Subject: METROWEST DCO EXAMINATION – ISSUE SPECIFIC HEARING 3 (ENVIRONMENTAL MATTERS) – ENVIRONMENT AGENCY WRITTEN RESPONSE TO AGENDA ITEM 5 (FLOOD RISK, DRAINAGE AND CONTAMINATED WATERS)

Our ref: WX/2019/133441/01-L09
Your ref: TRO40011
Date: 10 January 2021

**METROWEST DCO EXAMINATION – ISSUE SPECIFIC HEARING 3
(ENVIRONMENTAL MATTERS) – ENVIRONMENT AGENCY WRITTEN RESPONSE
TO AGENDA ITEM 5 (FLOOD RISK, DRAINAGE AND CONTAMINATED WATERS)**

- Flood Zone 3b
- Hallen Marsh (wetland habitat area)
- Environment Agency main rivers
- Avonmouth Rhine network
- Bristol City Boundary

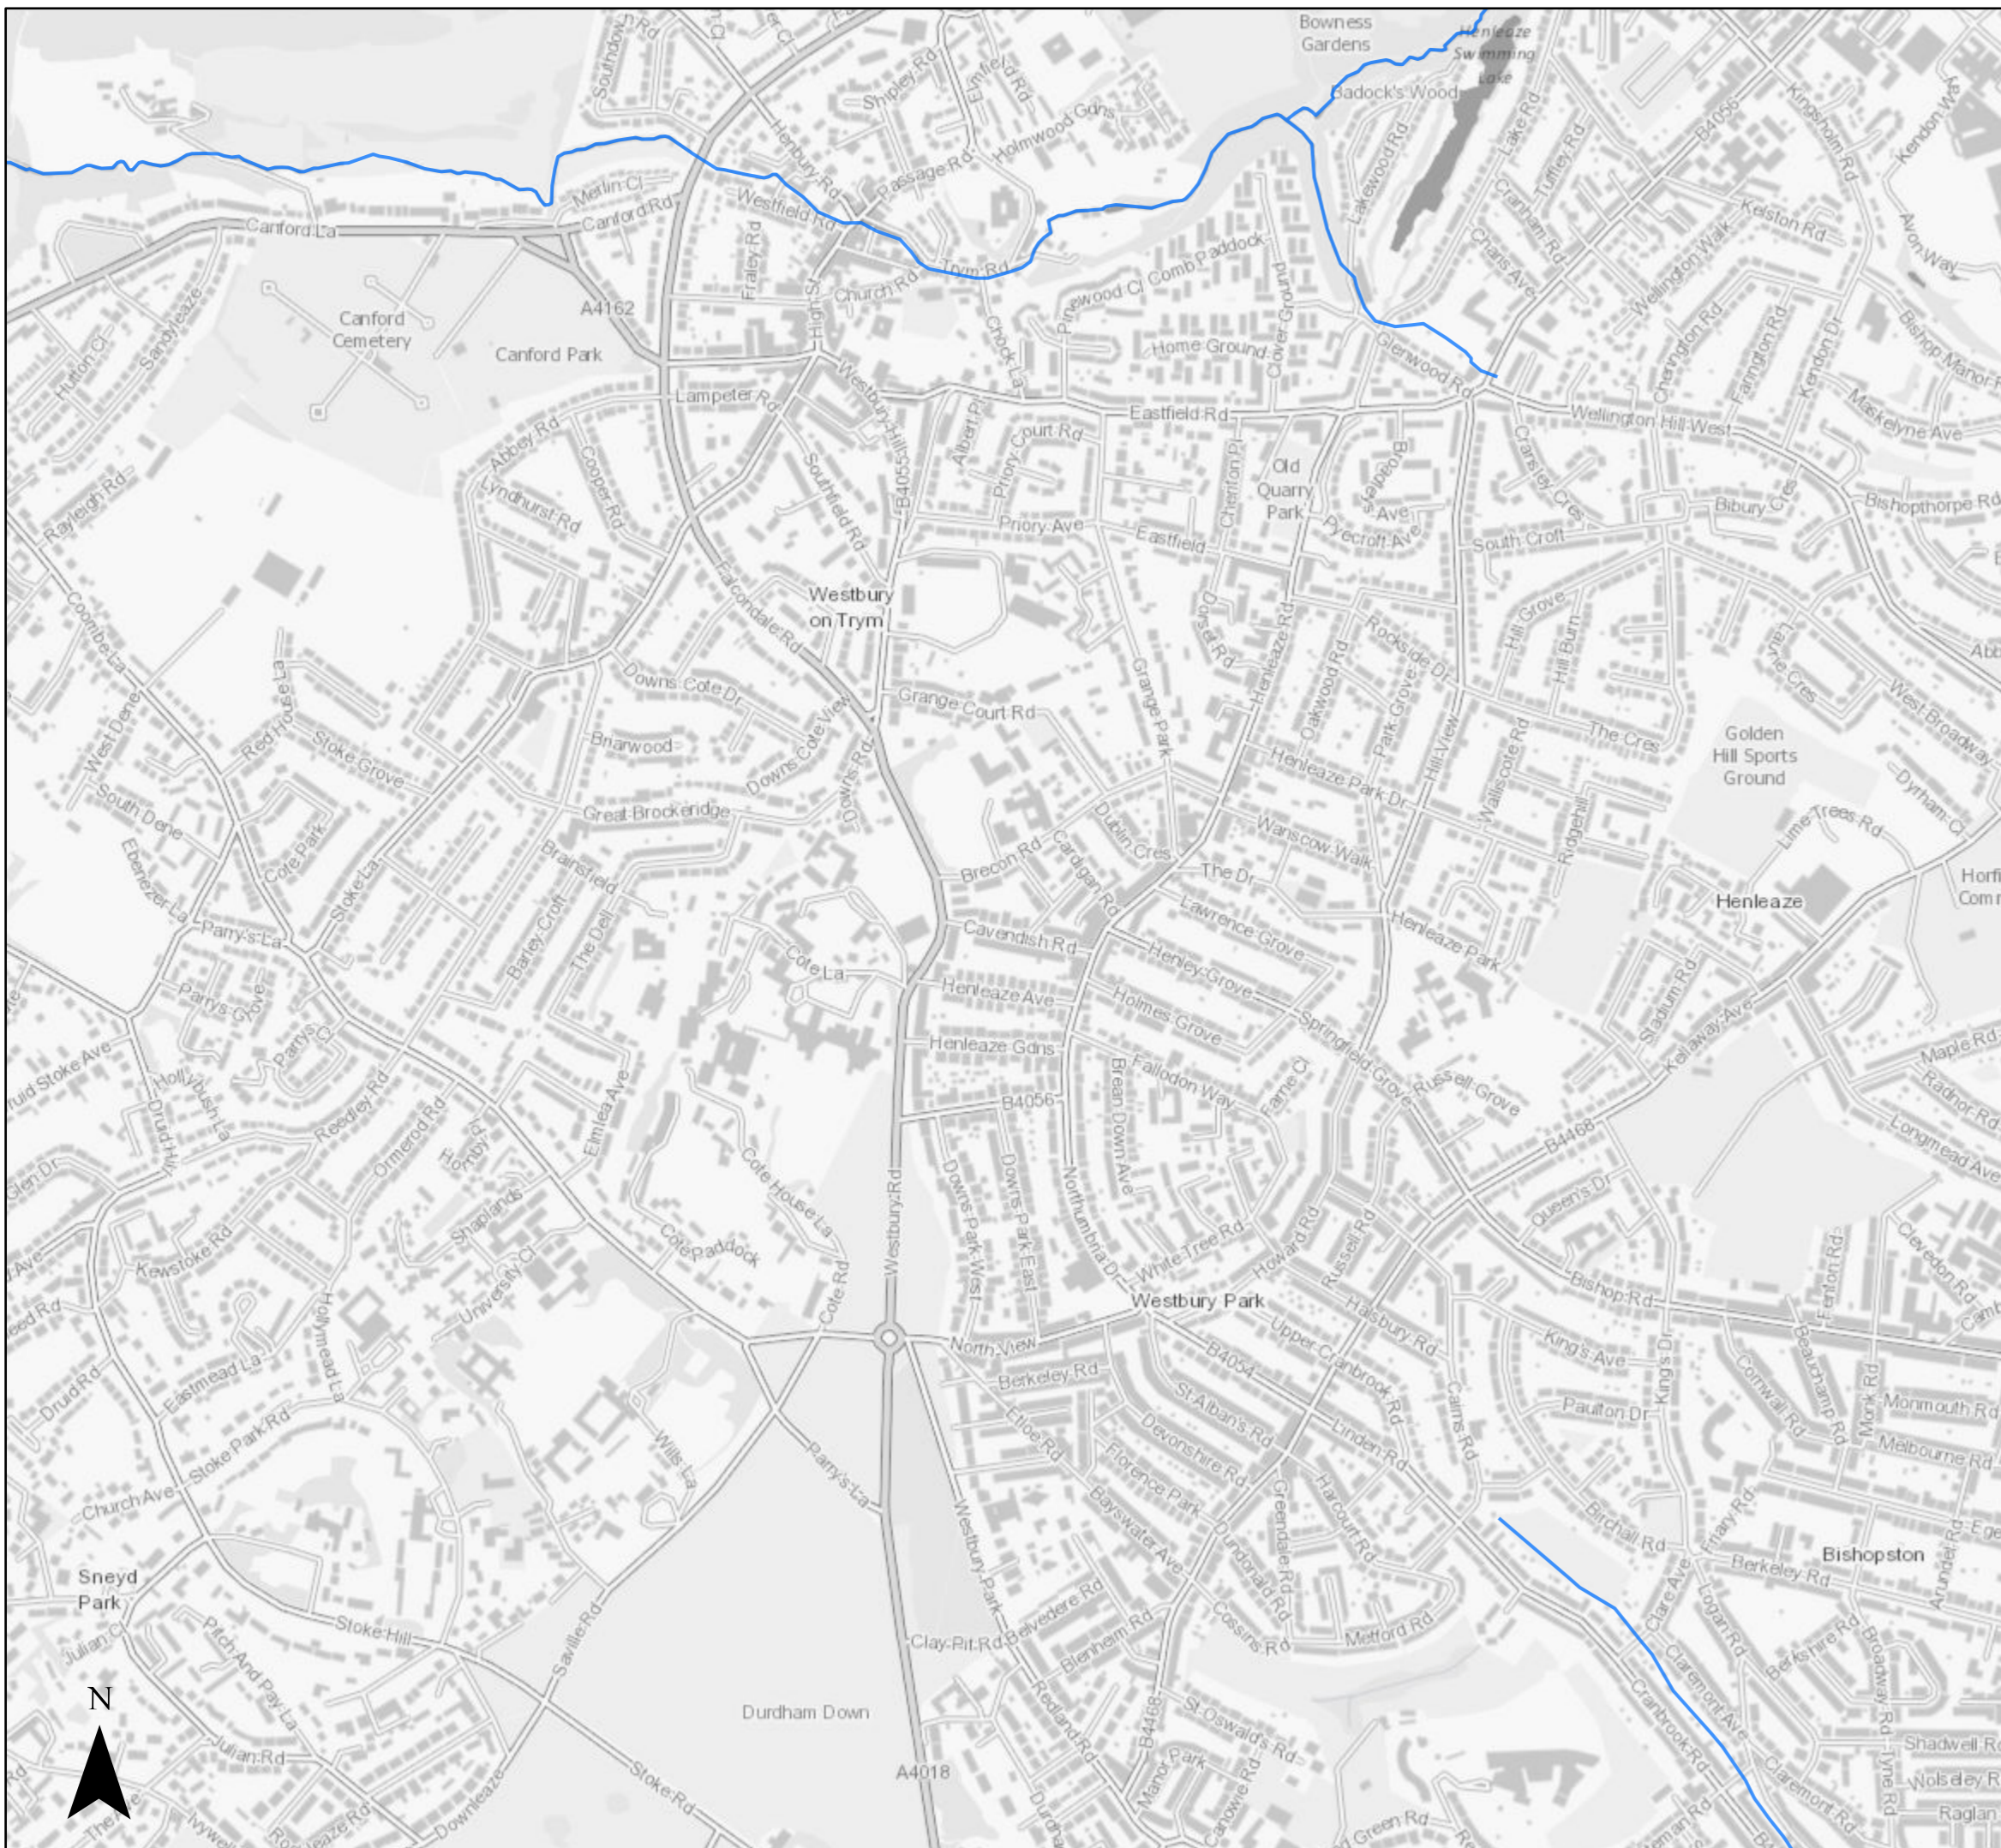
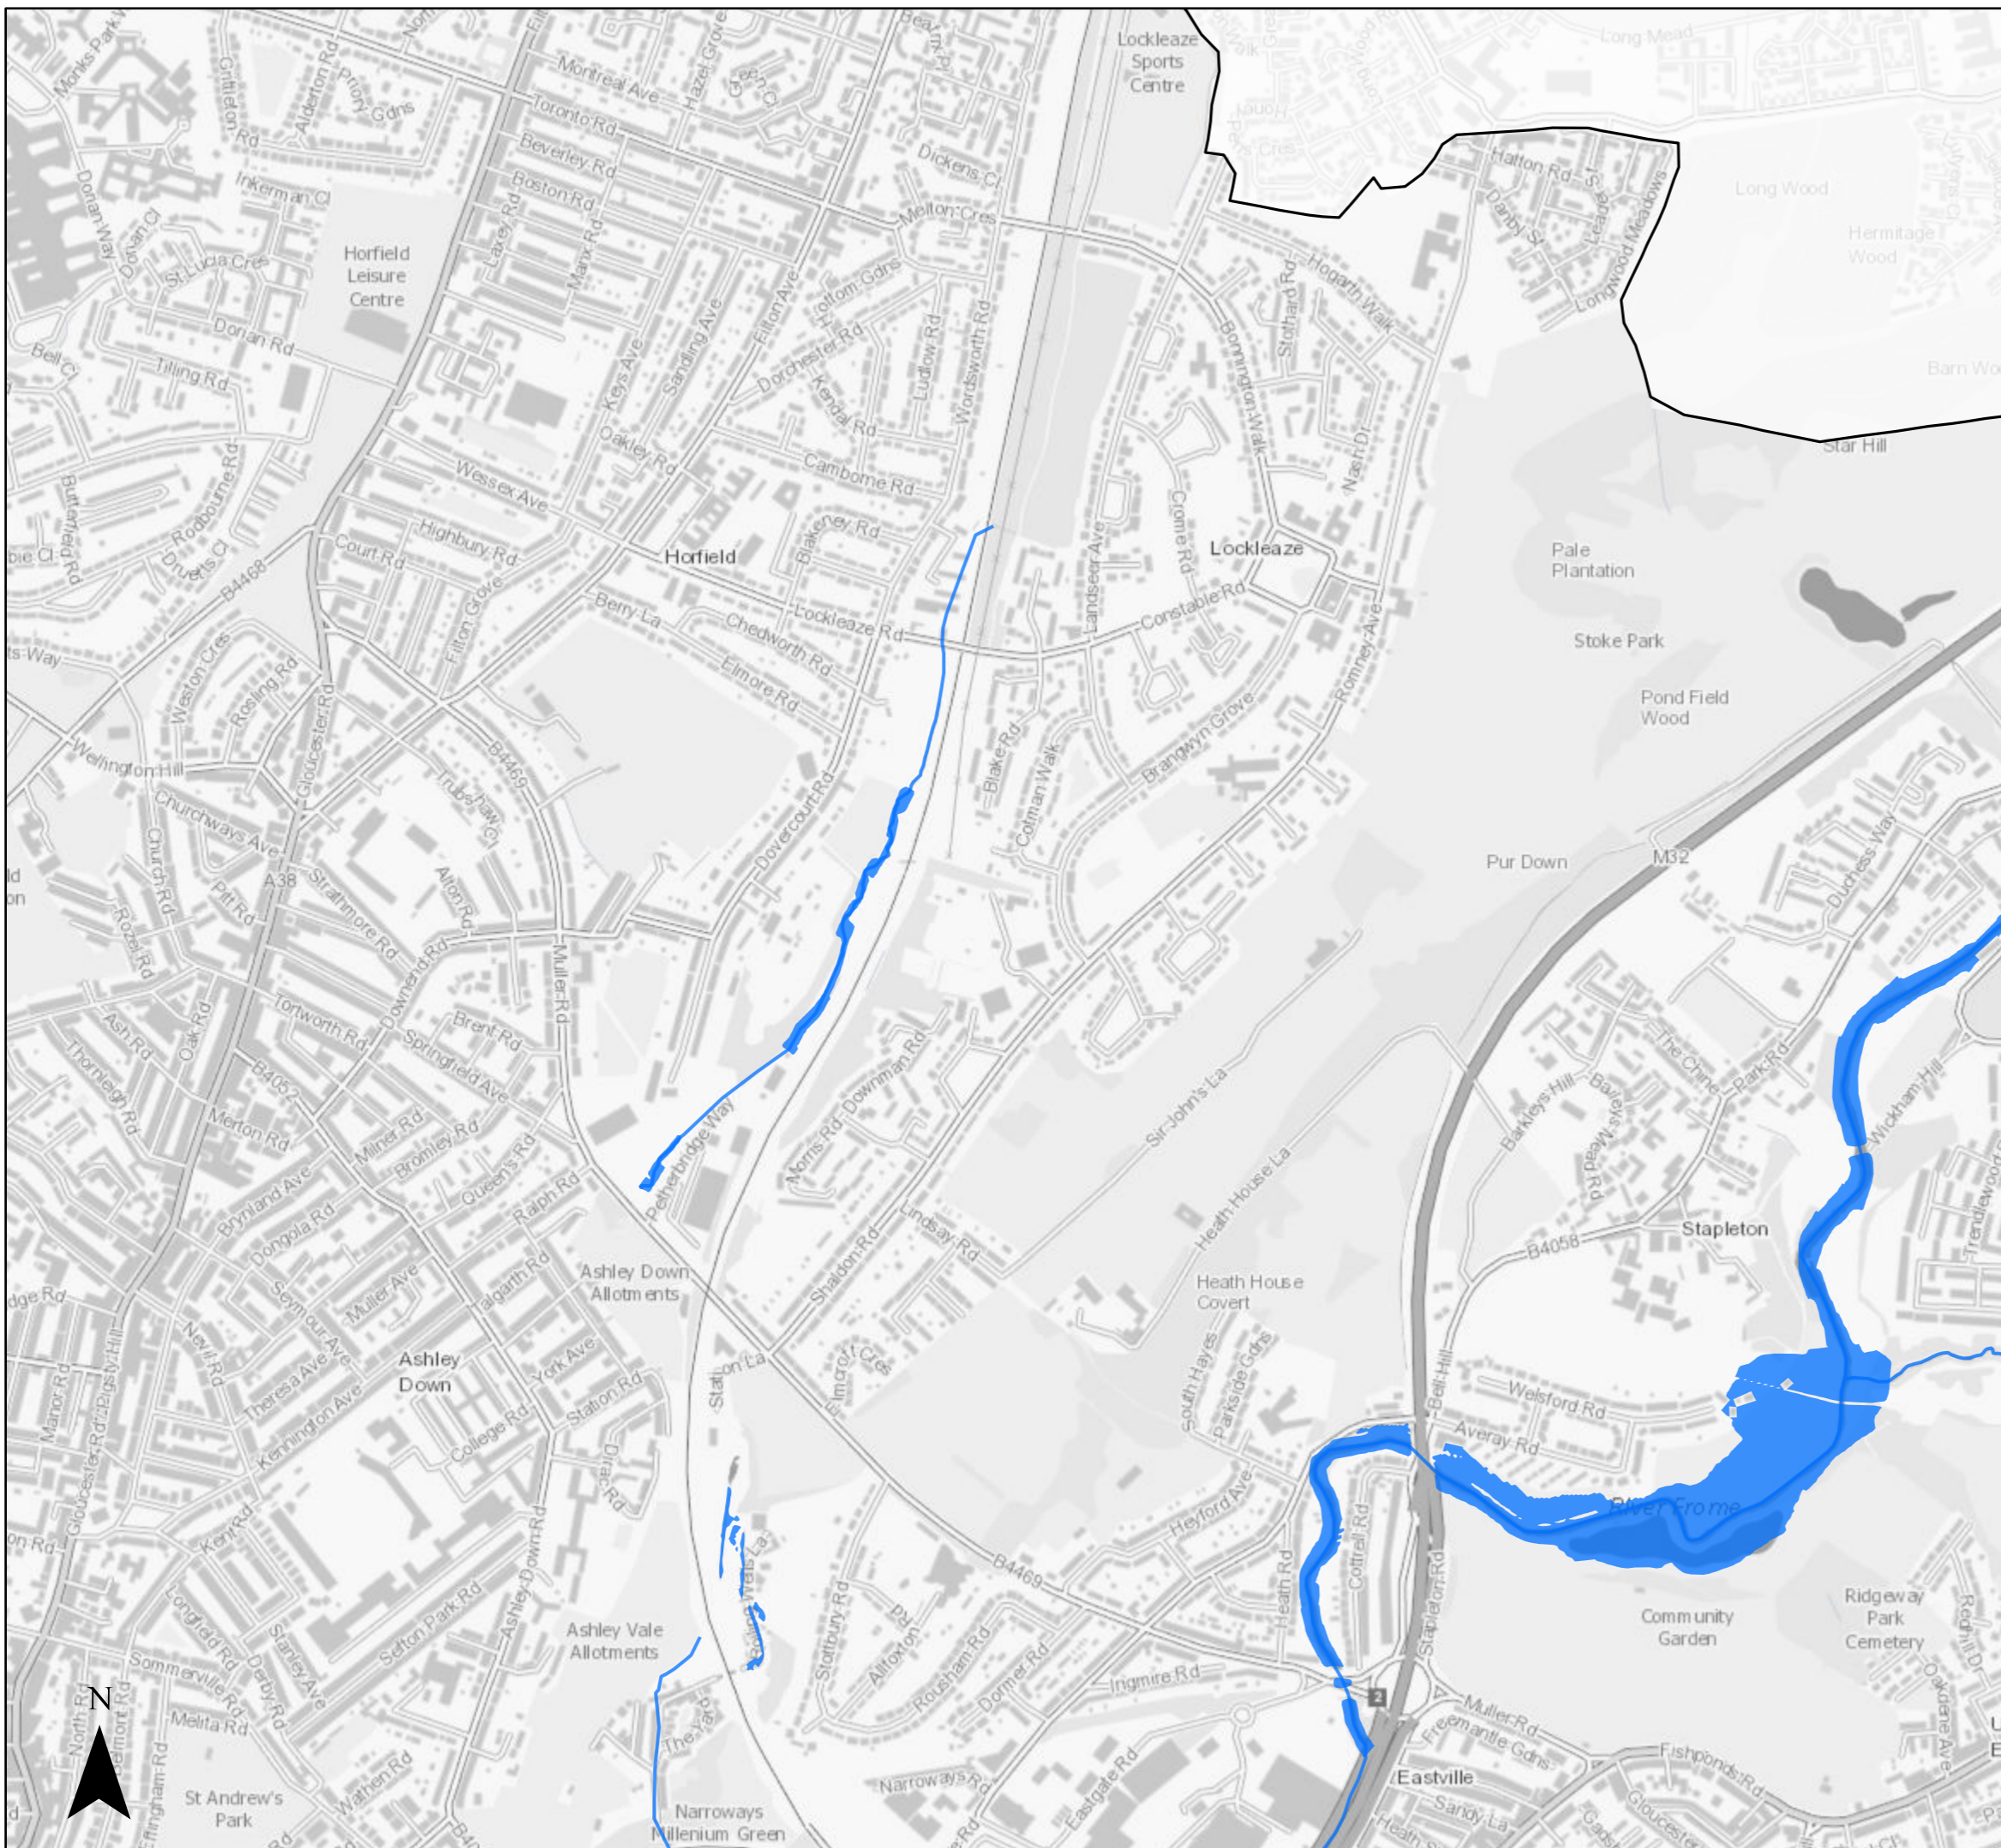
The applicant's representatives have recently cited the updated Bristol Strategic Flood Risk Assessment as evidence that no part of the application area is located within Flood Zone 3b (functional floodplain). This is obviously at variance with the applicant's own site specific flood risk model, which should be considered a more detailed assessment of the actual flood risk. Accordingly, the Agency must advise that parts of the application area are within Flood Zone 3b (functional floodplain), as detailed in the applicant's Flood Risk Assessment.
